CITY OF ALBUQUERQUE

**RE: Chase Bank
5210 Eubank NE
Grading and Drainage Plan Stamp Date: 11/4/20
Hydrology File: F21D047A**

Based on the re-submittal received on 11/4/20, this project is approved for Administrative Amendment and Building Permit. As a reminder, if the project total area of disturbance (including the staging area and any work within the adjacent Right-of-Way) is 1 acre or more, then an Erosion and Sediment Control (ESC) Plan and Owner's certified Notice of Intent (NOI) is required to be submitted to the Stormwater Quality Engineer (Doug Hughes, PE, jhughes@cabq.gov, 924-3420) 14 days prior to any earth disturbance..

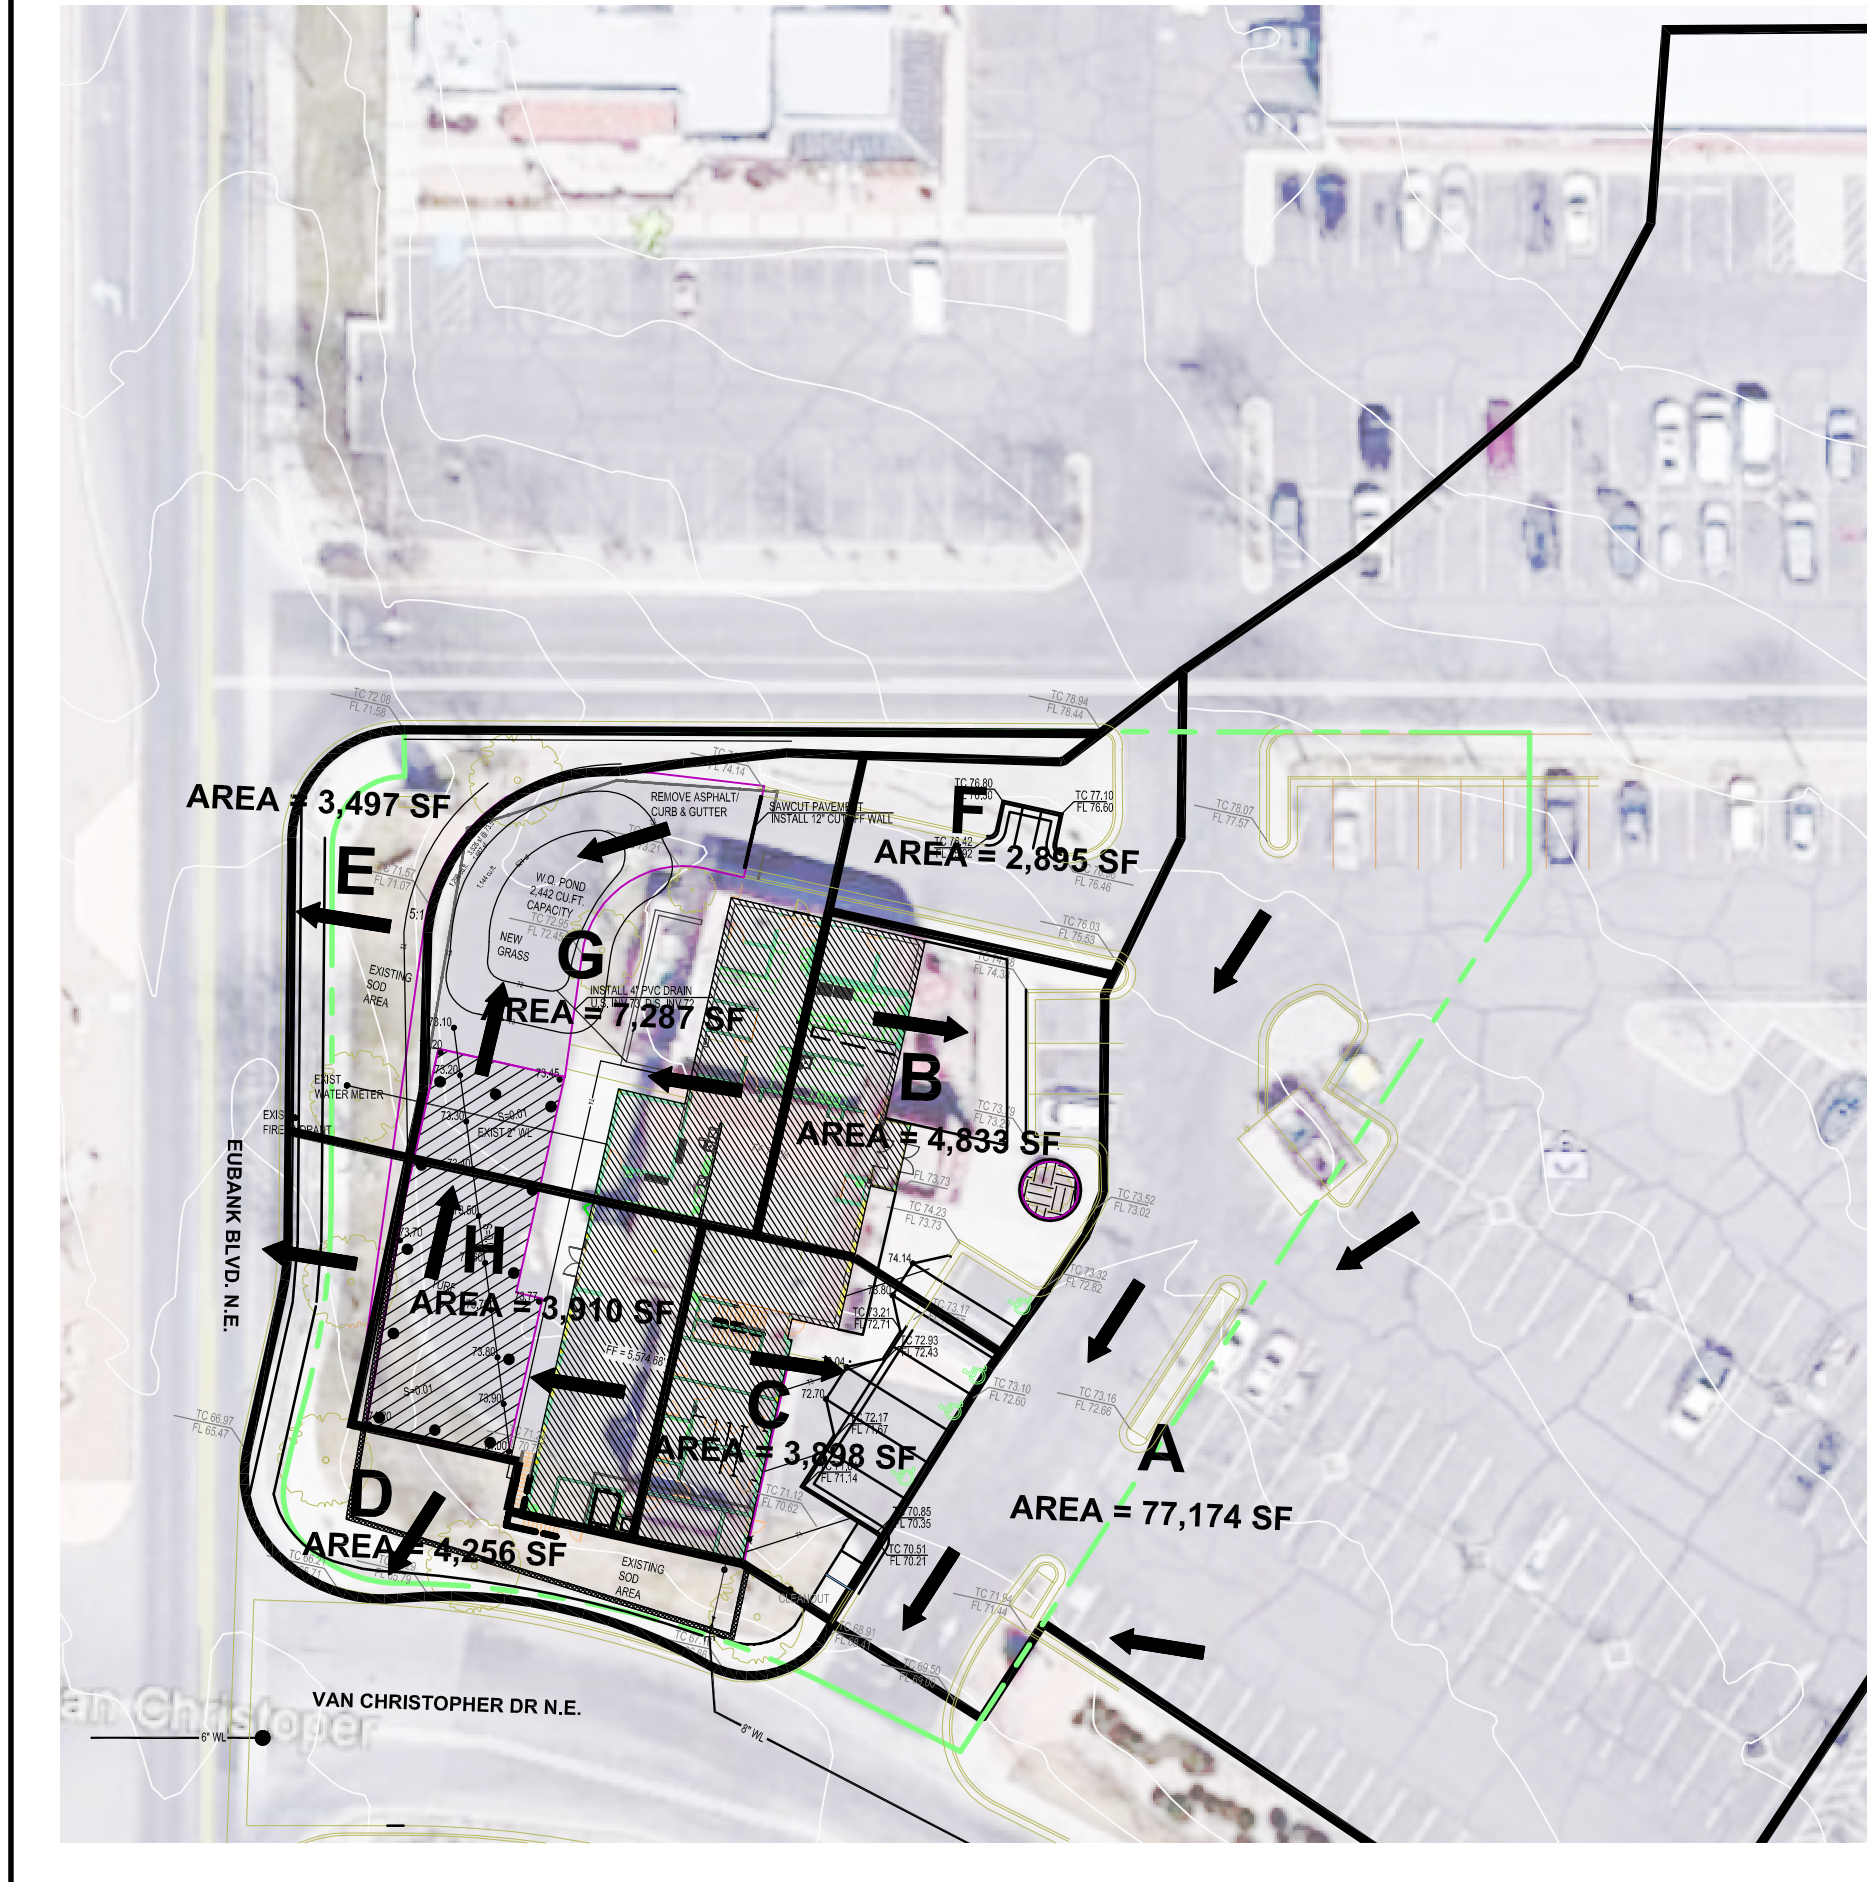
1. Engineer's Certification, per the DPM Chapter 22.7: *Engineer's Certification Checklist For Non-Subdivision* is required.
2. For the Storm Water Quality Volume which is not being captured by ponding Payment in Lieu (Amount = 211CF x \$8/CF = \$1688, per sheet C1) of onsite management of the SWQV must be made. Take three copies of the treasury deposit slip to the Treasury and then include one copy of the paid deposit slip when resubmitting.
